Submission No.			133		
Organisation Name or Name of Submitter			Irish Water (Uisce Eireann)		
Item No.	Section Ref.	Page No.	Observation Statement	TII Response	
Letter Re: Railway Order Application- Metro North: Estuary through Swords, Dublin Airport, Ballymun, Glasnevin and City Centre to Charlemont, Co. Dublin					
1	Cover letter	2	<p>Irish Water is cognisant of the significant number of interactions the MetroLink scheme will have with both existing Irish Water infrastructure and future planned infrastructure. It is imperative that Irish Water’s infrastructure, both existing and planned, is protected and future proofed to ensure continued provision of critical services. Examples of these interactions include, but are not limited to, multiple diversions and crossings of existing Irish Water assets, interactions with the Greater Dublin Drainage Project, Swords Pumping Station, Catchment Drainage Area Plans and infrastructure projects such as Fosterstown Wastewater Sewer upgrade, North Fringe Sewer and the Dublin City Sewerage Scheme.</p>	<p>TII commit to protecting existing IW infrastructure and to continuing to engage with Irish Water to ensure the detailed designs for MetroLink i

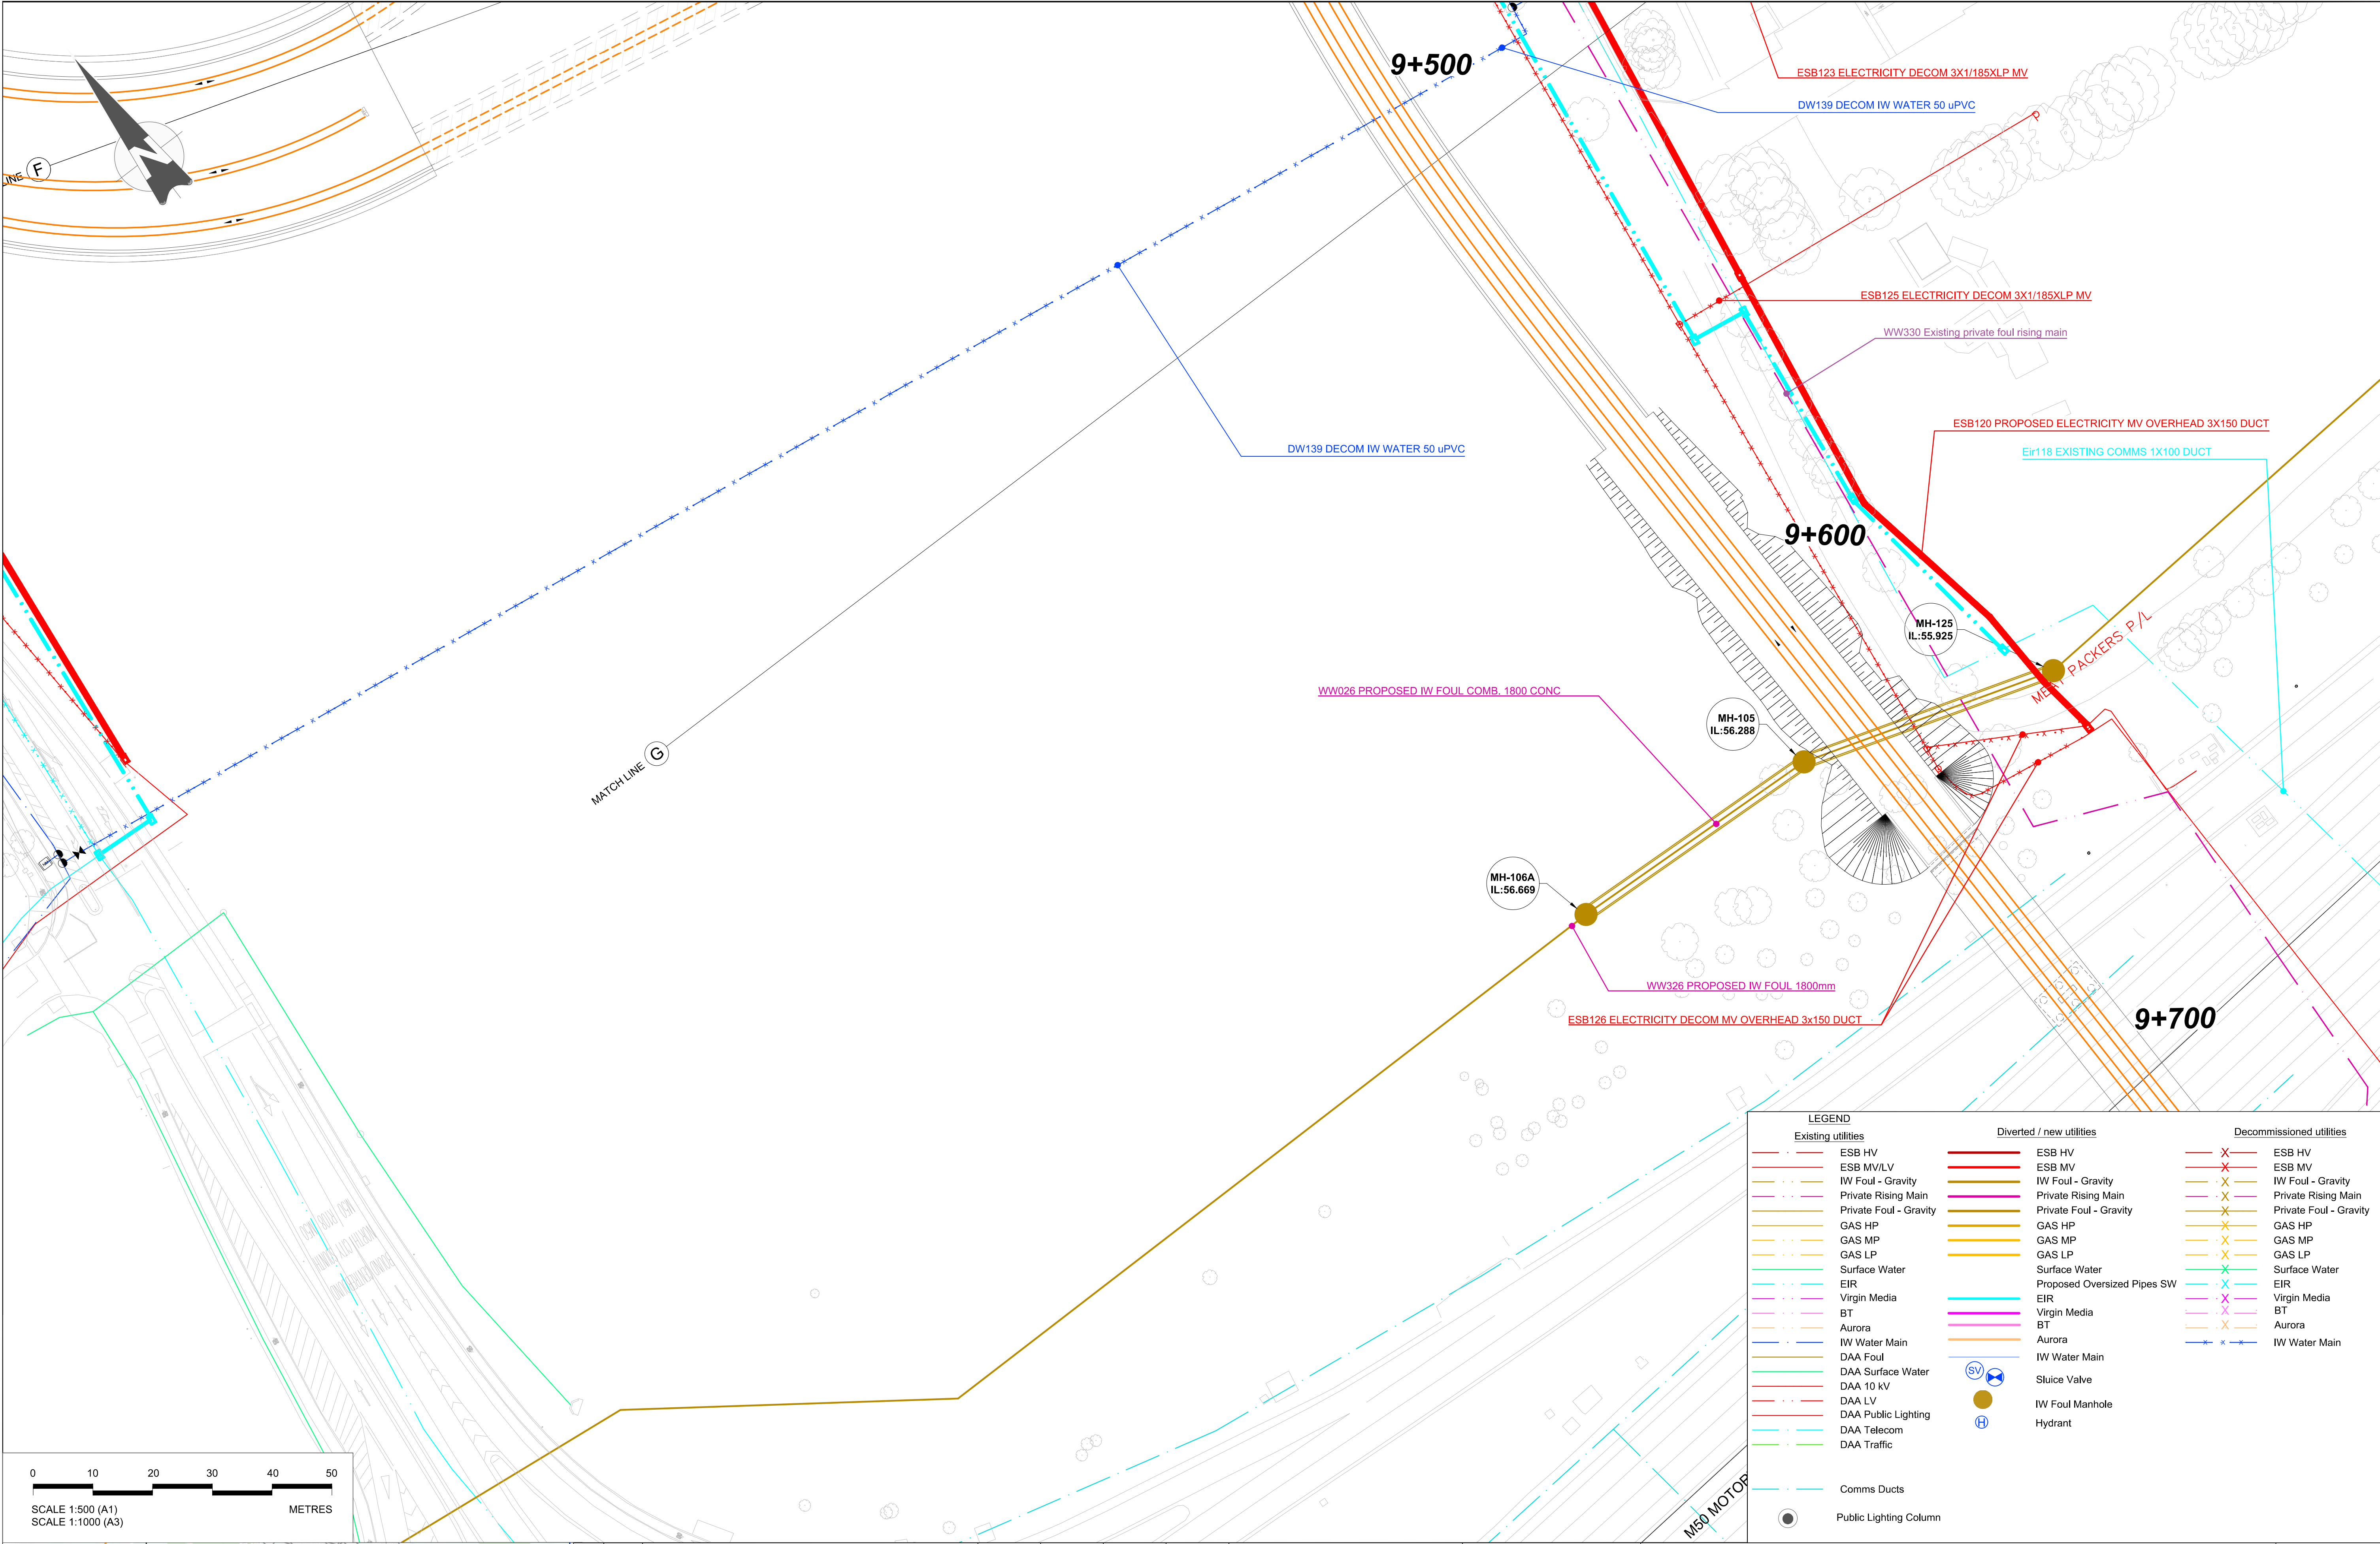
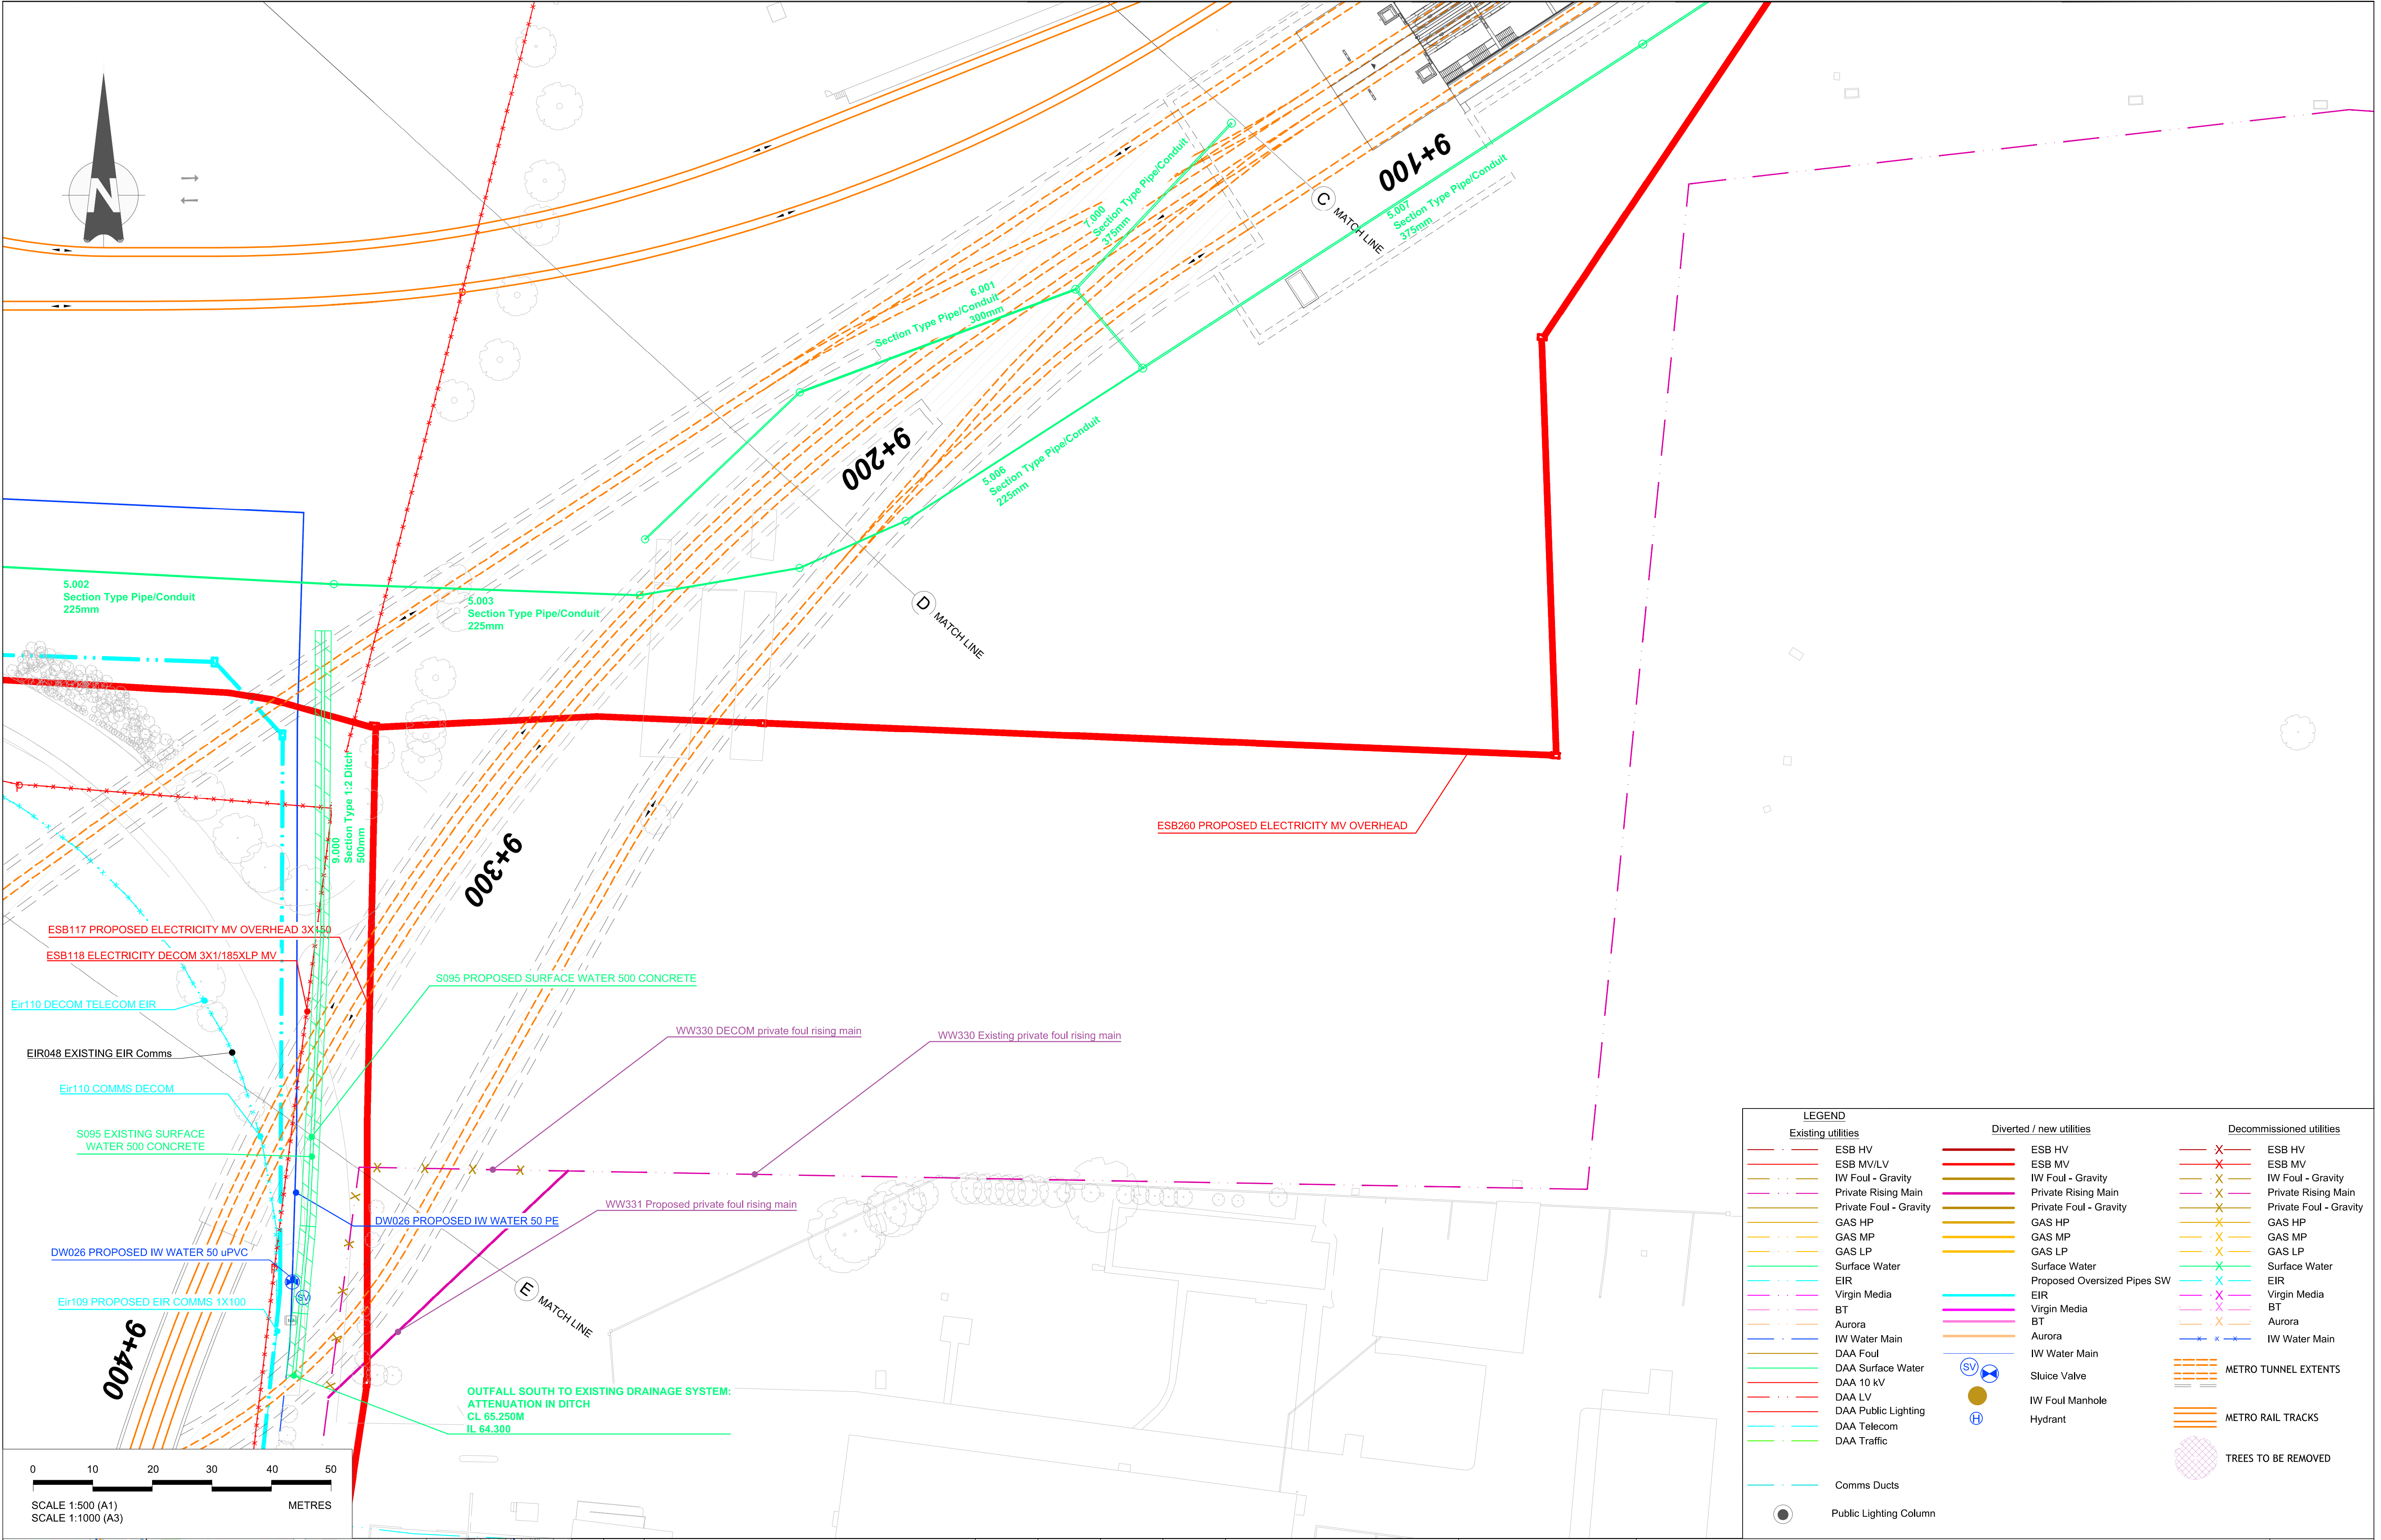
29	Description of the Known and Future Likely Interactions M) Greater Dublin Drainage (GDD) Project GDD and MetroLink Interaction – Details (ii) Status of GDD Orbital Sewer	14	The proposed GDD orbital sewer is shown on the Applicant’s utility drawings as an existing sewer (drawing reference ML1-JAI-URD-SC01_XX-DR-Y-01050 – extract shown in Appendix 4, Figure 4). It is noted that this pipeline has yet to be constructed (as set out above the GDD project is currently the subject of a SID planning application). In addition, it is noted that details and levels as shown in the MetroLink application are inconsistent with those provided by Irish Water in the GDD planning application (GDD planning drawing reference 32102902-2102 – figure 3). The MetroLink application should be updated to reflect the correct details for the GDD orbital sewer.	Please refer to (4) above, the horizontal alignment is correctly shown, the drawing shall be updated to reflect the correct number of manholes and invert levels and an erratum to the Railway Order Submitted. The details and levels shown for the GDD were previously provided by IW and used in the RO submission. However, subsequent to the submission of the Railway Order application, TII updated the drawings and information to reflect the GDD planning drawings. It will be important that the horizontal and vertical alignment is precisely defined where it crosses the MetroLink alignment for the purpose of design and construction coordination (and these will be provided to ABP at the oral hearing). TII note that the updated correct alignment has been assessed, and whilst it is not considered that an updated GDD alignment has a material impact on the MetroLink Railway Order application, it will be required and used for the detailed design phase. Subsequent detailed discussions with IW have been based on the correct information
